Phone: 0300 123 6780  
Email: [Kathryn.Walsh@lancashire.gov.uk](mailto:Kathryn.Walsh@lancashire.gov.uk)  
Your ref: 3/2025/0197  
Our ref: 3/2025/0197/HDC/KW  
Date: 22 April 2025

**Location:** Ethos House York Street Clitheroe BB7 2DL  
**Proposal:** Change of use of restaurant (use class E) to offices on the ground floor, and three one bedroom apartments (use class C3) on the first floor, including external alterations to the building.  
**Grid Ref:** 374457 441950

### Summary

#### **No objection subject to conditions**

Drawing Title
Proposed Plans and Elevations

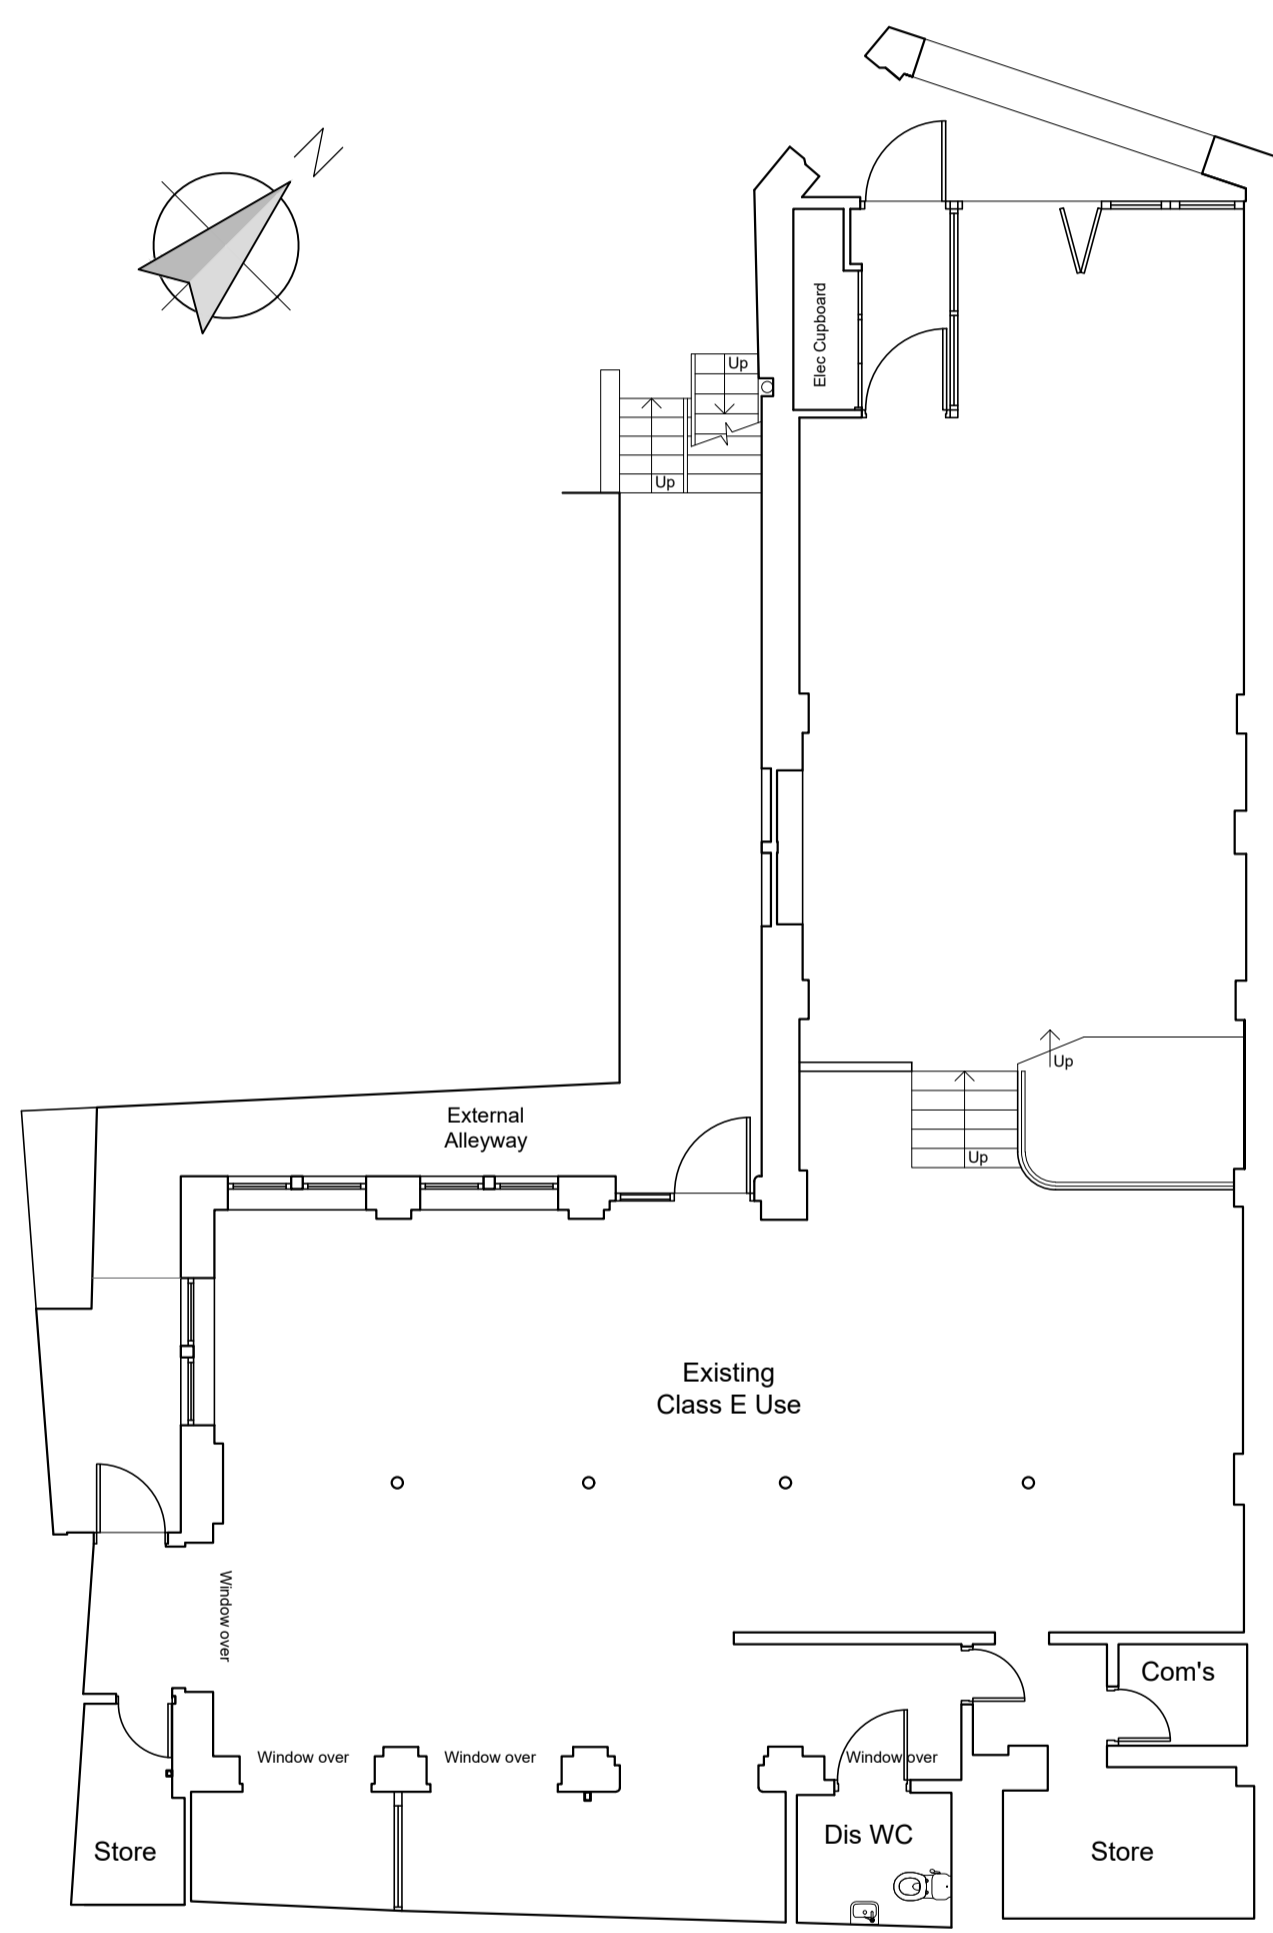
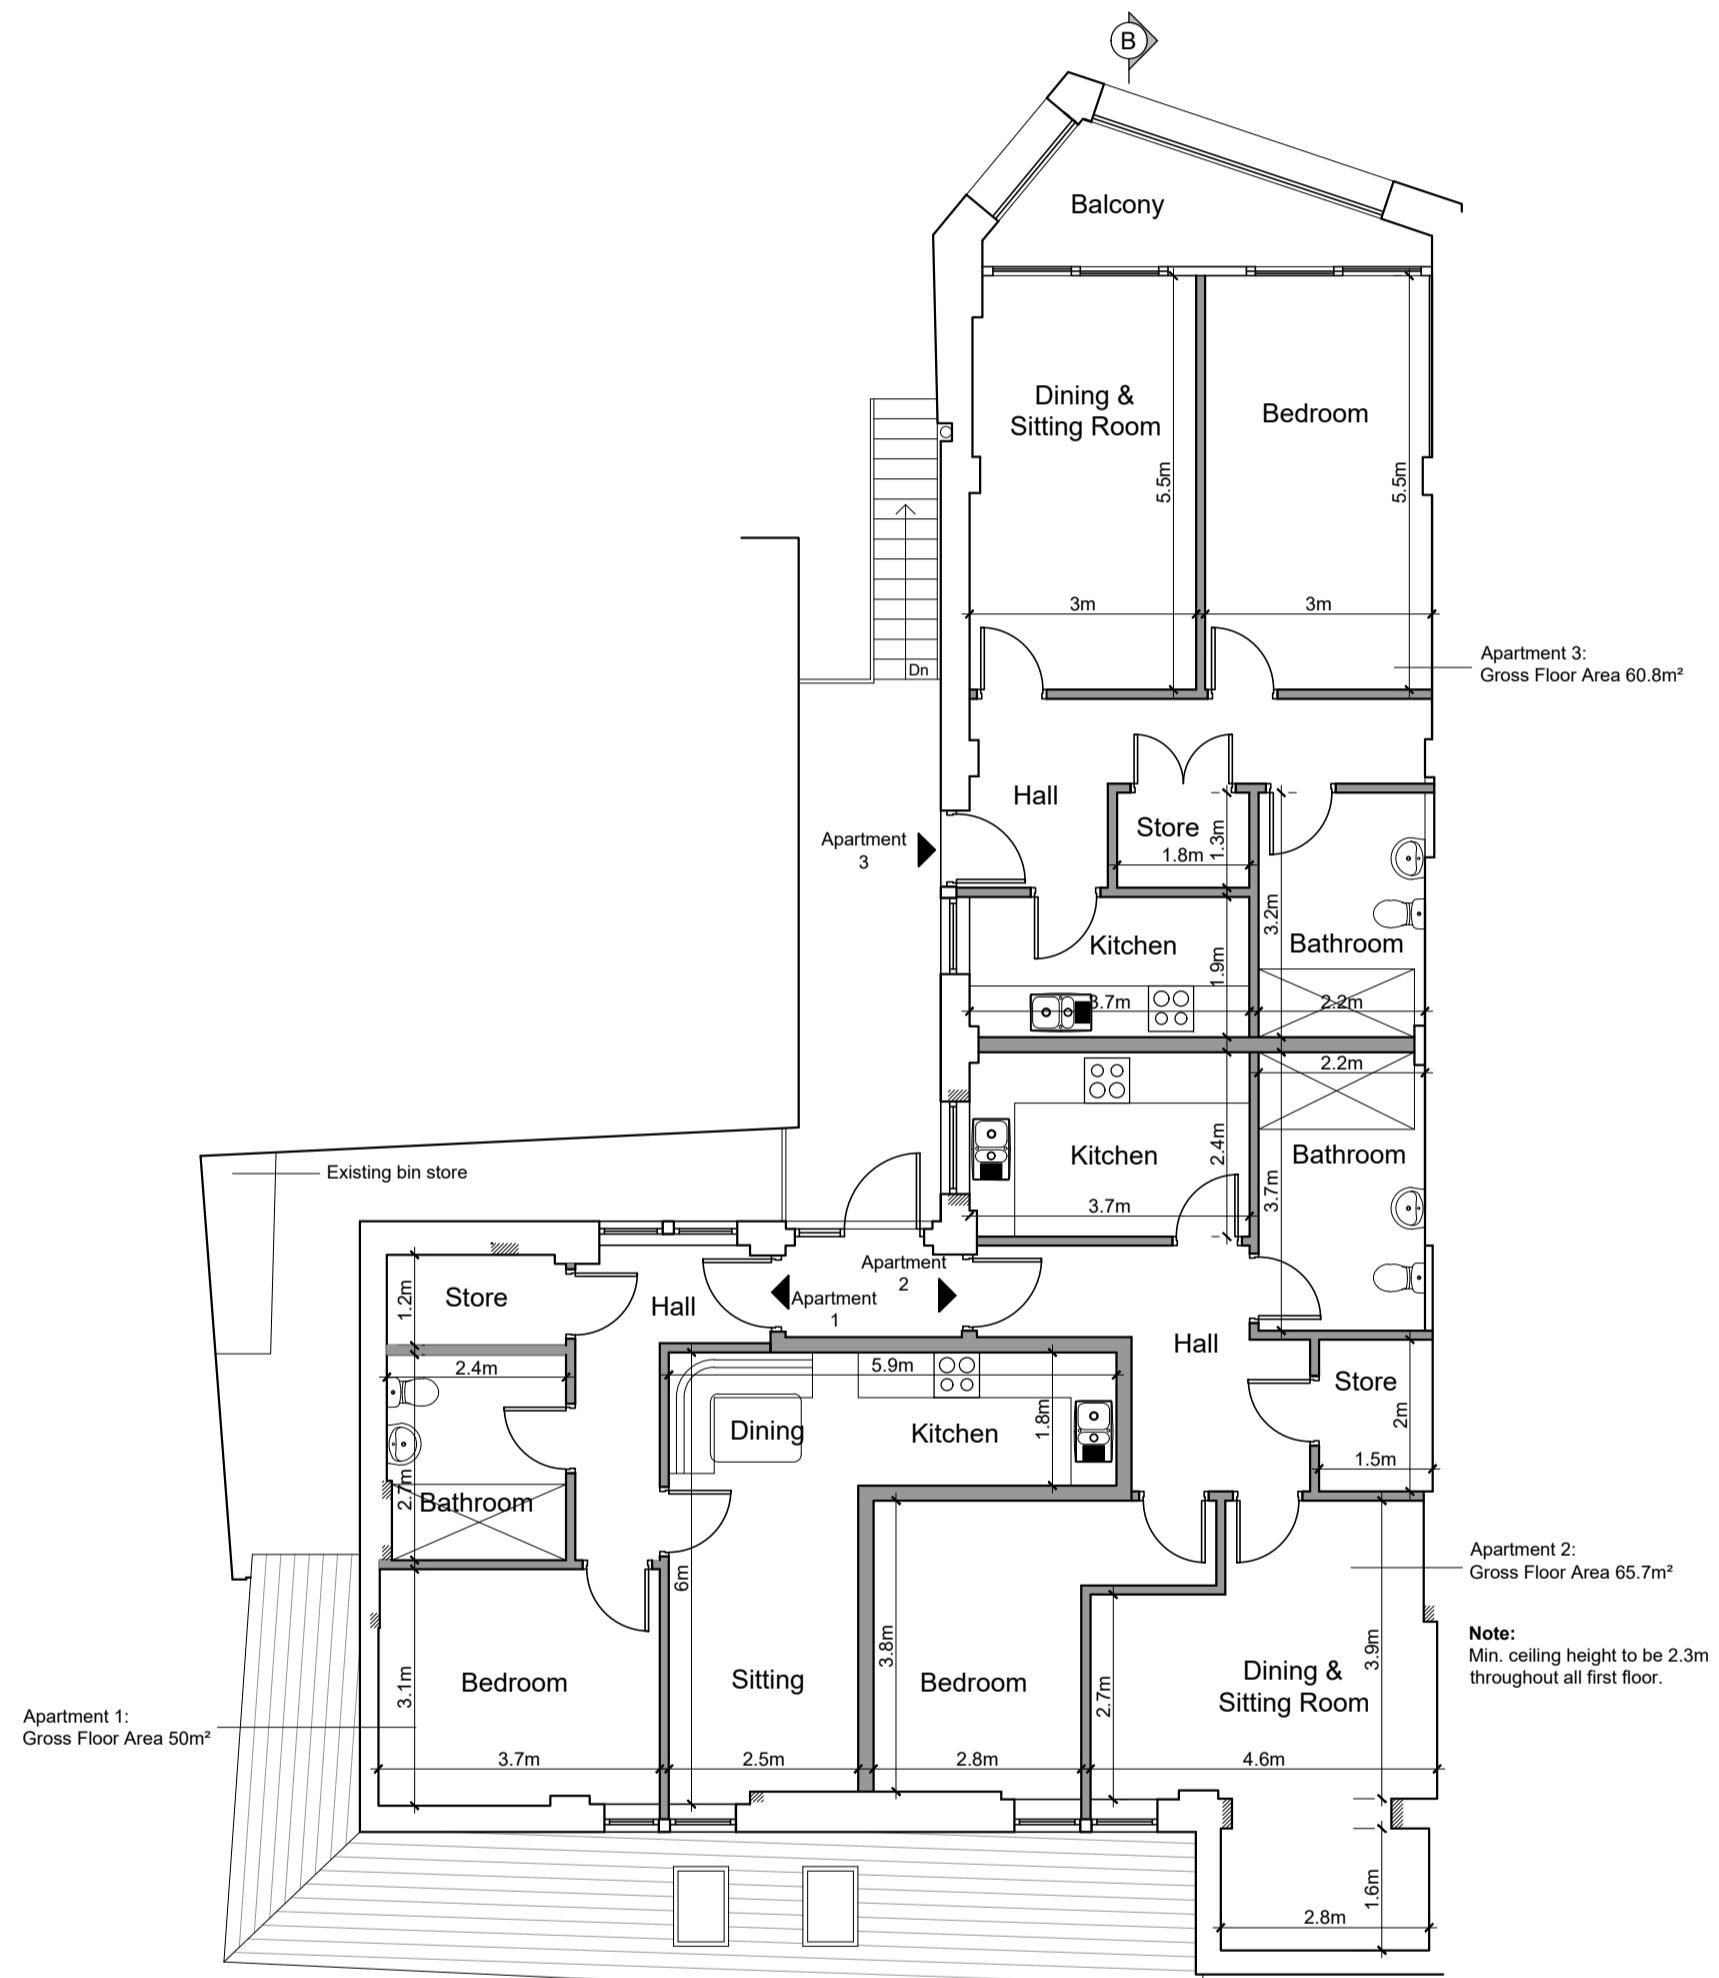
The LHA has reviewed the proposed plans, drawing number 6006 P03 Rev C, and note that the proposal will retain the existing entrance for the ground floor and that the first-floor apartments will be accessed through an external alleyway adjacent to the existing doorway.

The LHA have reviewed the supporting documents and are aware that no car parking facilities will be provided for the proposed 3 x 1 apartments. For the site to comply with the LHAs parking guidance as defined within the Joint Lancashire Structure Plan, the LHA require 3 car parking spaces to be provided for the apartments and 6 car parking spaces for the proposed offices when considering the internal measurements.

1. Prior to first occupation covered and secure cycle storage suitable for 3 bicycles shall be provided within the development.
